**DELEGATED HOUSEHOLDER DECISION**

168 TOLCARNE DRIVE PINNER

The application seeks planning permission for a first storey side extension with conversion of existing integral garage to habitable room and the erection of a single storey rear extension and front porch extension.

REVISION: A	Revised Scheme
PREVIOUS APPROVAL : 57721/APP/2003/1833	
PROJECT:	168 Tolcarne Drive Pinner HA5 2DR
DRAWING:	Proposed Floor Plans
SCALE:	1:100 @A3
DATE:	Dec 2024
PAGE NO:	168 - P - D
STATUS:	PLANNING DRAWINGS
All dimensions to be checked on site prior to CONSTRUCTION.

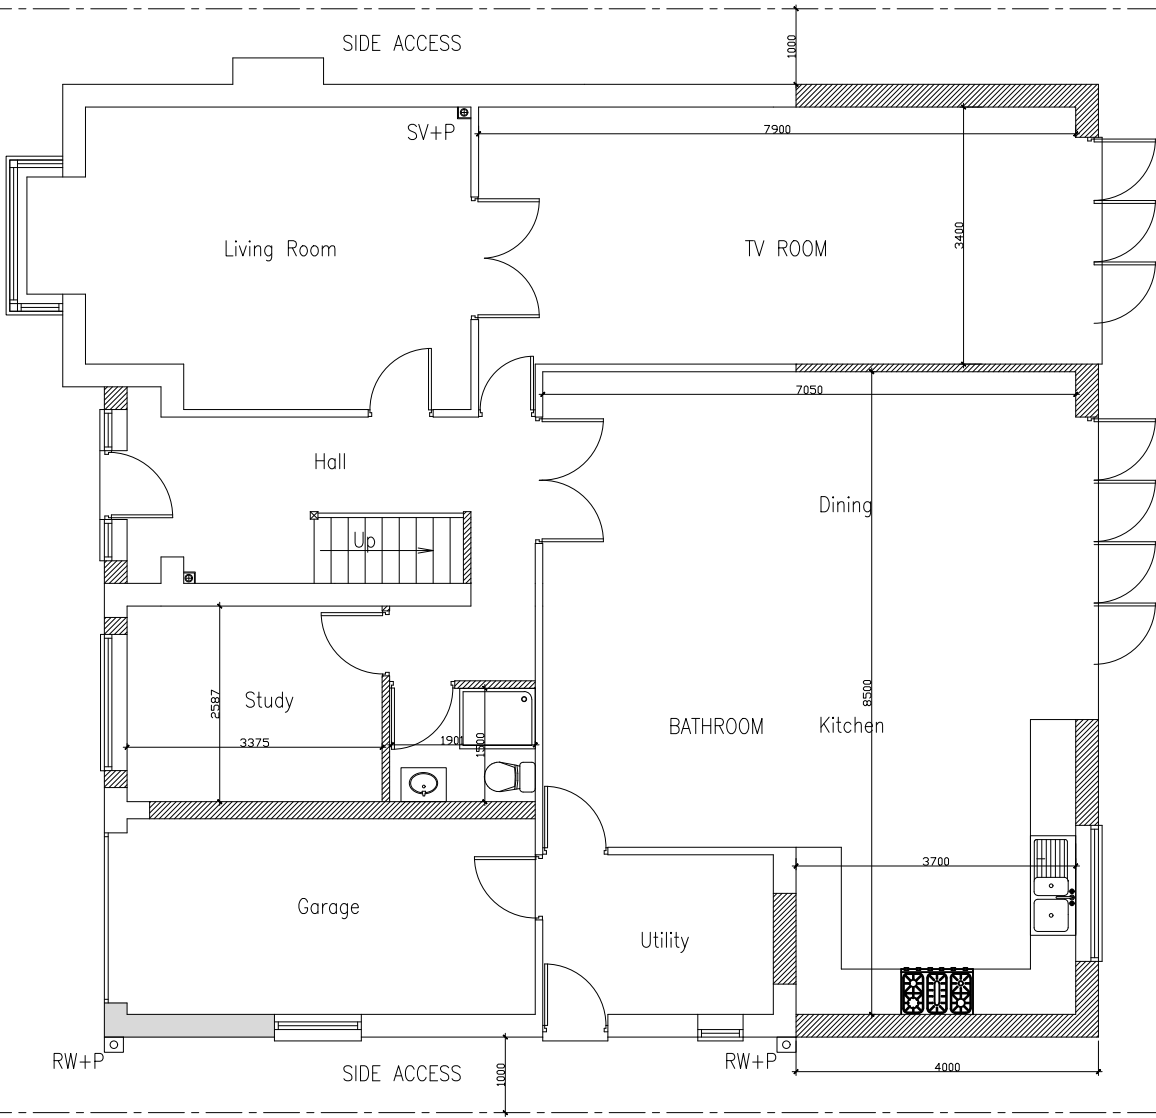
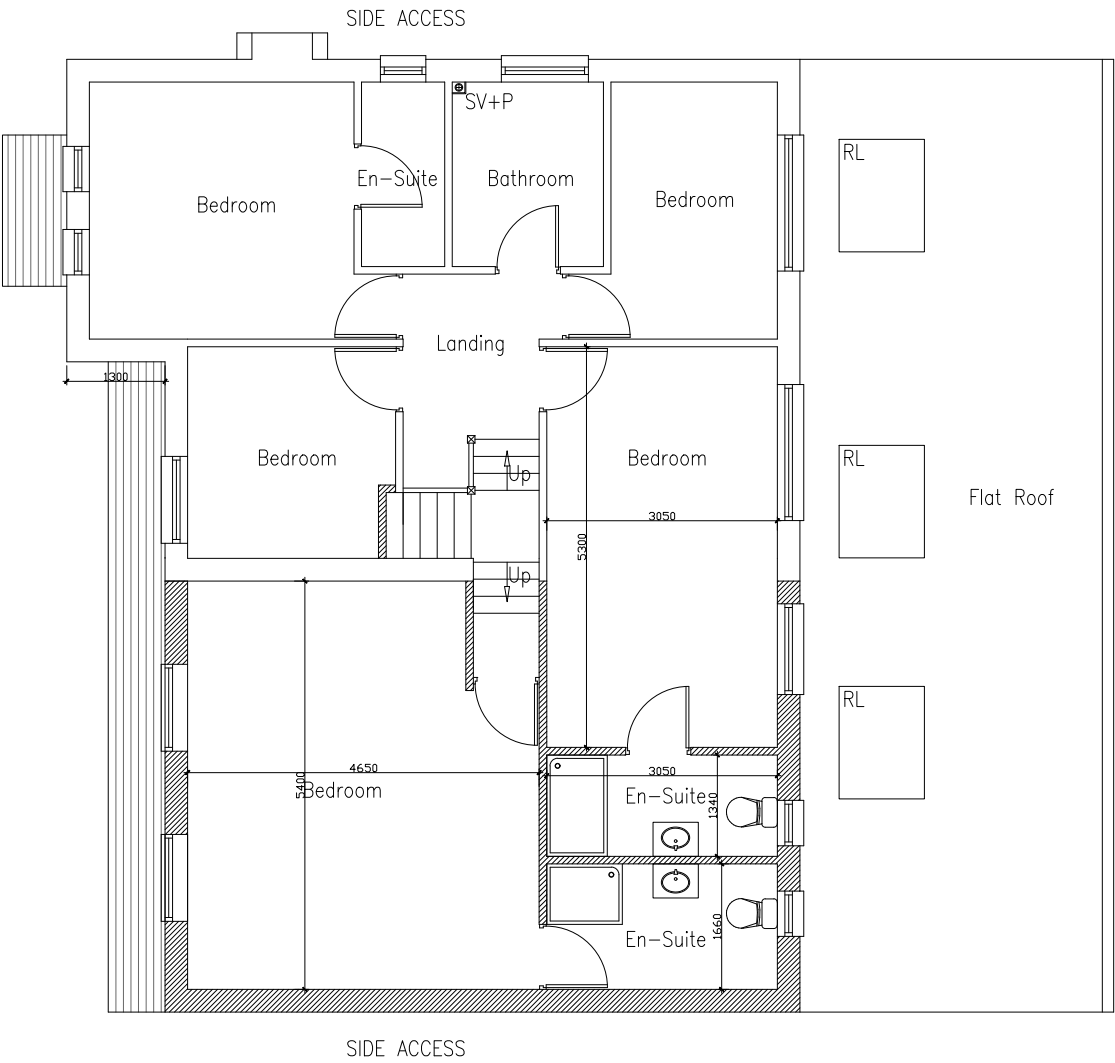
The proposed first floor side extension would have a width of 5.675m and a depth of 9.00m and would be characterised with a gable end roof form in line with the existing main ridge line of the roof with two new first floor front facing windows. The proposed single storey rear extension would have a depth of 4.00m, a width of 12.40m and would be characterised with a pitched roof with a maximum height of 3.00m and an eaves height of 2.85m. The proposed front porch extension would have a width of 2.50m, a depth of 1.00m and would be characterised with a pitched roof with a maximum height of 2.32m and an eaves height of 2.40m. The proposed conversion of garage to habitable room would include amendments to fenestrations including a new window and brickwork to the front elevation and an extension of the front porch canopy over the new window and retained garage door.

The proposed first floor side extension would be sited above the existing integral garages and would have a width of 5.675m which would exceed half the width of the original dwelling at first floor level. Despite this, it is noted that the double garage projects to the side at ground floor level and contributes to the width of the original dwelling. The proposed first floor extension would be sited above the double garage and would sit within the original footprint of the dwelling, meaning it would appear as suitably subordinate to the original dwelling.

The proposed single storey rear extension, with a depth of 4.00m would be in accordance with the requirements of Policy DMHD 1 of the Hillingdon Local Plan: Part Two - Development Management Policies (2020). The proposed rear extension would be considered a subordinate addition to the host dwelling which would not result in any harm to its character or appearance.

The proposed front porch extension, which would infill the space between the existing front projection and the existing integral garages would be considered a minor alteration to the front elevation of the dwelling, in accordance with Policy DMHD 1 of the Hillingdon Local Plan: Part Two - Development Management Policies (2020). At least 25% of the front garden would be retained, in accordance with Policy DMHD 1.

In addition, the proposed conversion of garage to habitable room with the removal of the existing garage door and installation of a new window and brickwork would be considered a minor alteration to the front elevation of the dwelling, in accordance with Policy DMHD 1 of the Hillingdon Local Plan: Part Two - Development Management Policies (2020). The conversion would be acceptable in design terms. One garage would be retained to the north side of the dwelling. The front canopy would also be extended from the front porch to cover the new window and the retained garage door, this would be considered acceptable in design terms.

The proposal results in the loss of one integral garage. Despite this, the property has hardstanding at the front of the property, and could accommodate at least two cars and one integral garage that would be retained, in accordance with Policy DMT 6 of the Hillingdon Local Plan Part 2: Development Management Policies (2020).
